From: Sarah Burrow <Sarah.Burrow@arun.gov.uk>
Sent: 11 January 2021 18:31
To: Planning.Responses <Planning.Responses@arun.gov.uk>
Cc: Amber Willard <Amber.Willard@arun.gov.uk>
Subject: RE: Planning Consultation on: FP/231/20/PL

Engineers Comments Regarding Surface Water Drainage

Application No: FP/231/20/PL
Registered: 27th November 2020
Site Address: Abergail Clyde Road Felpham PO22 7AH
Grid Reference: 494872 99350
Description of Works: New building with first floor 1 No. 1- bed apartment above (3 x No.) garages a&cycle store with parking. This site is in CIL Zone 4 (Zero Rated) as flat.

PROPOSED PLOT PLAN

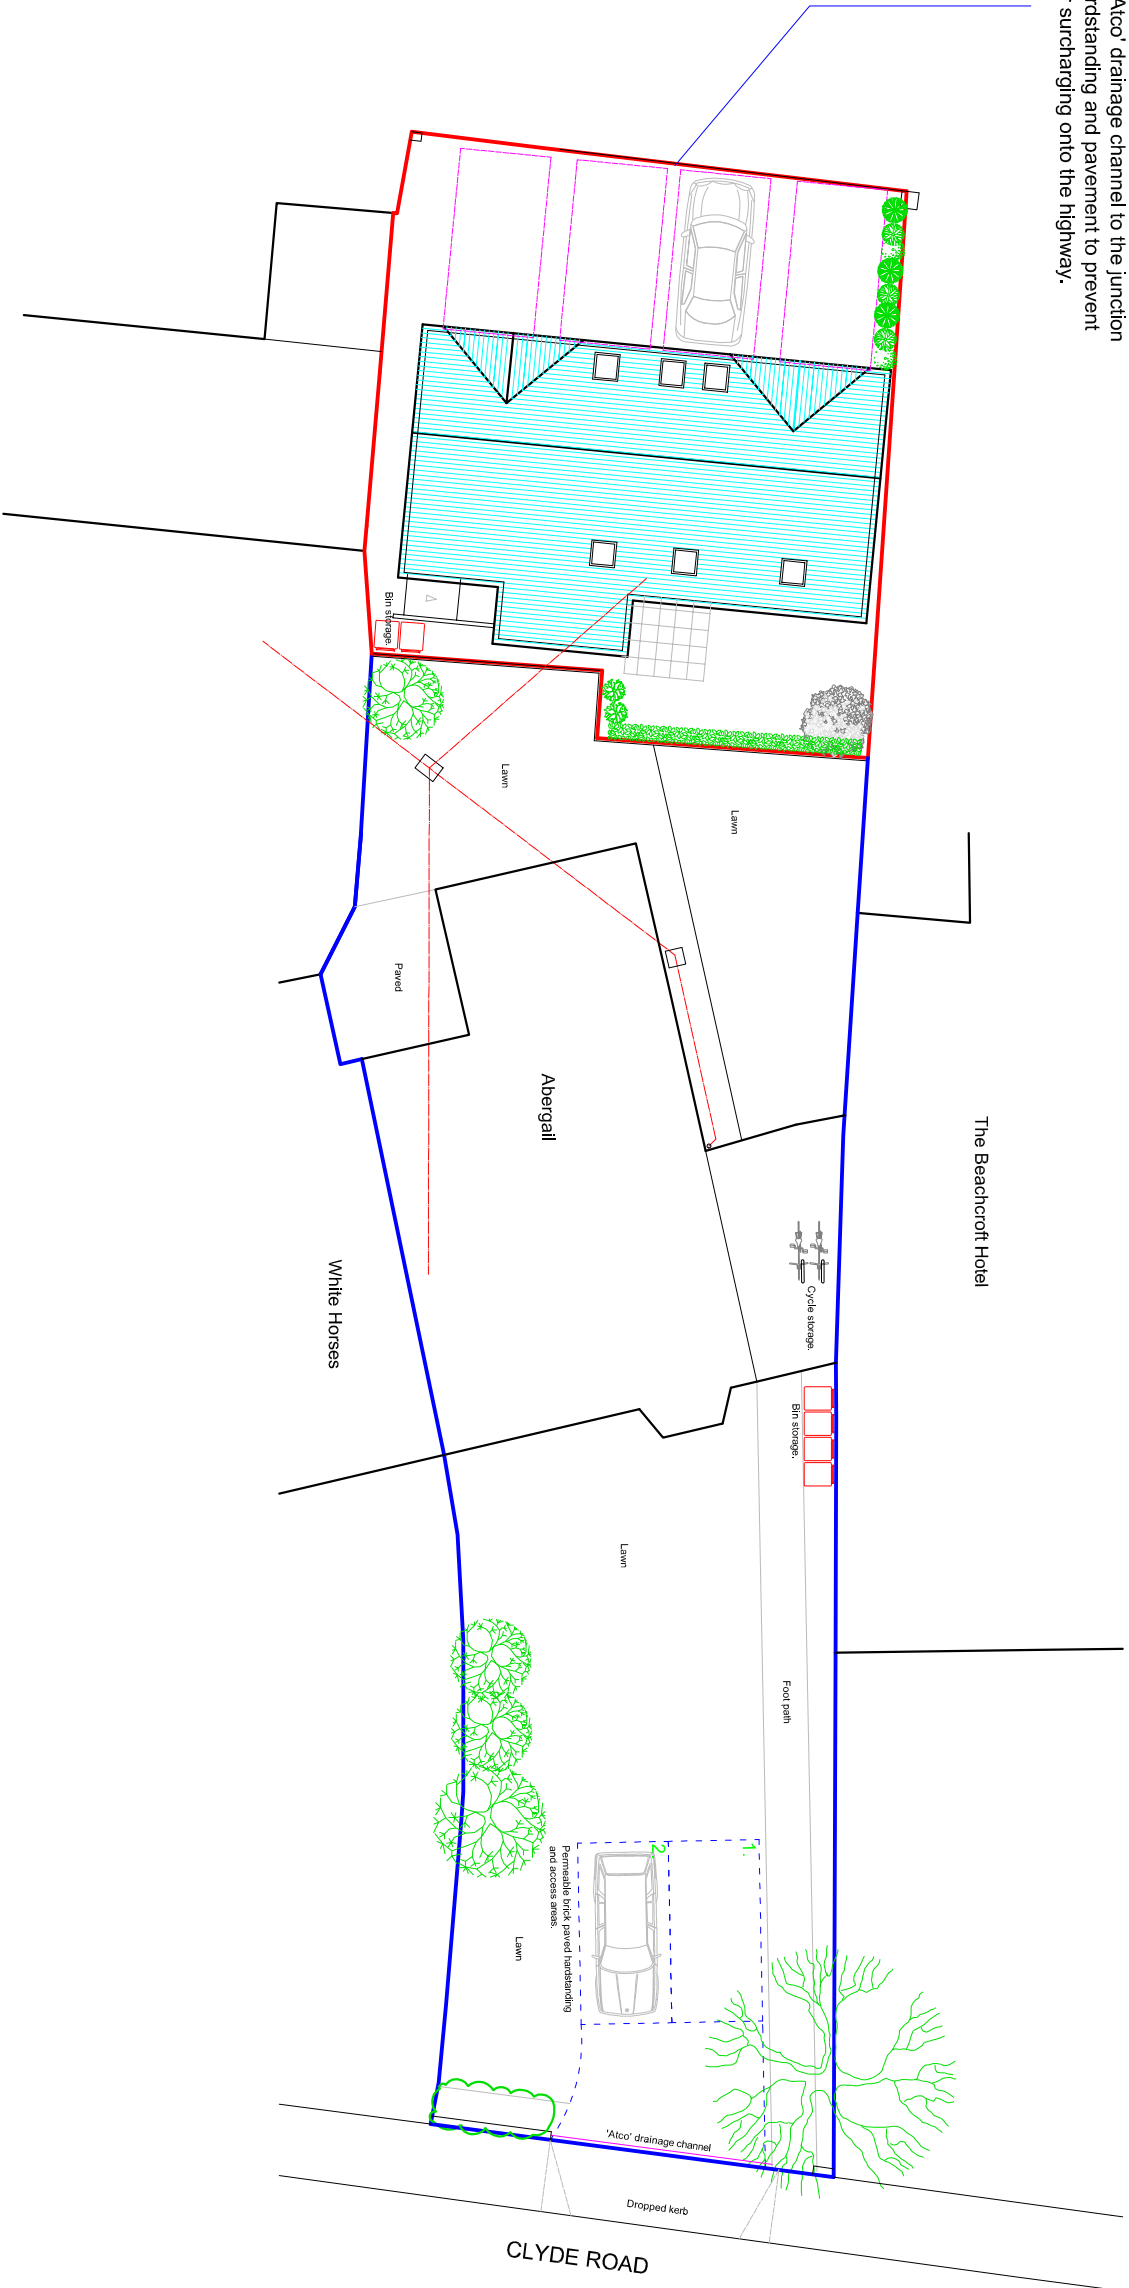
If infiltration is viable on the site then lack of space is not an adequate excuse for not utilising soakaways/infiltration structures. Soakaways must be located a minimum of 5m from any buildings, and 2.5m from the site boundaries. Given these constraints, it is not possible for surface water from the site to be sustainably drained within the red line boundary of the site. The applicant indicates an intention to drain surface water via a newly built soakaway in the front garden of Abergail within the same ownership but not within the application site.

Therefore, I wish to lodge a holding objection to the application.

It is understood that the applicant also owns the remaining plot for Abergail, (within the blue line boundary) and it is accepted that if the red line boundary was to be redrawn to include the indicated area in the front garden of Abergail then there will be sufficient space for surface water drainage. In this instance I would be happy to withdraw the objection and instead recommend the application of standard condition PCENG2 (should you be minded to approve the application).

“Development shall not commence, other than works of site survey and investigation, until full details of the proposed surface water drainage scheme have been submitted to and approved in writing by the Local Planning Authority. The design should follow the hierarchy of preference for different types of surface water drainage disposal systems as set out in Approved Document H of the Building Regulations, and the recommendations of the SuDS Manual produced by CIRIA. Winter groundwater monitoring to establish highest annual ground water levels and winter Percolation testing to BRE 365, or similar approved, will be required to support the design of any Infiltration drainage. No building / No part of the extended building shall be occupied until the complete surface water drainage system serving the property has been implemented in accordance with the agreed details and the details so agreed shall be maintained in good working order in perpetuity.”

“Infiltration rates for soakage structures are to be based on percolation tests undertaken in the winter period and at the location and depth of the proposed structures. The percolation tests must be carried out in accordance with BRE365, CIRIA R156 or a similar approved method and cater for the 1 in 10 year storm between the invert of the entry pipe to the soakaway, and the base of the structure. It must also have provision to ensure that there is capacity in the system to contain below ground level the 1 in 100 year event plus 40% on stored volumes, as an allowance for climate change. Adequate freeboard must be provided between the base of the soakaway structure and the highest recorded annual groundwater level identified in that location. Any SuDS or soakaway design must include adequate groundwater monitoring data to determine the highest winter groundwater table in support of the design. The applicant is advised to discuss the extent of groundwater monitoring with the Council's Engineers.
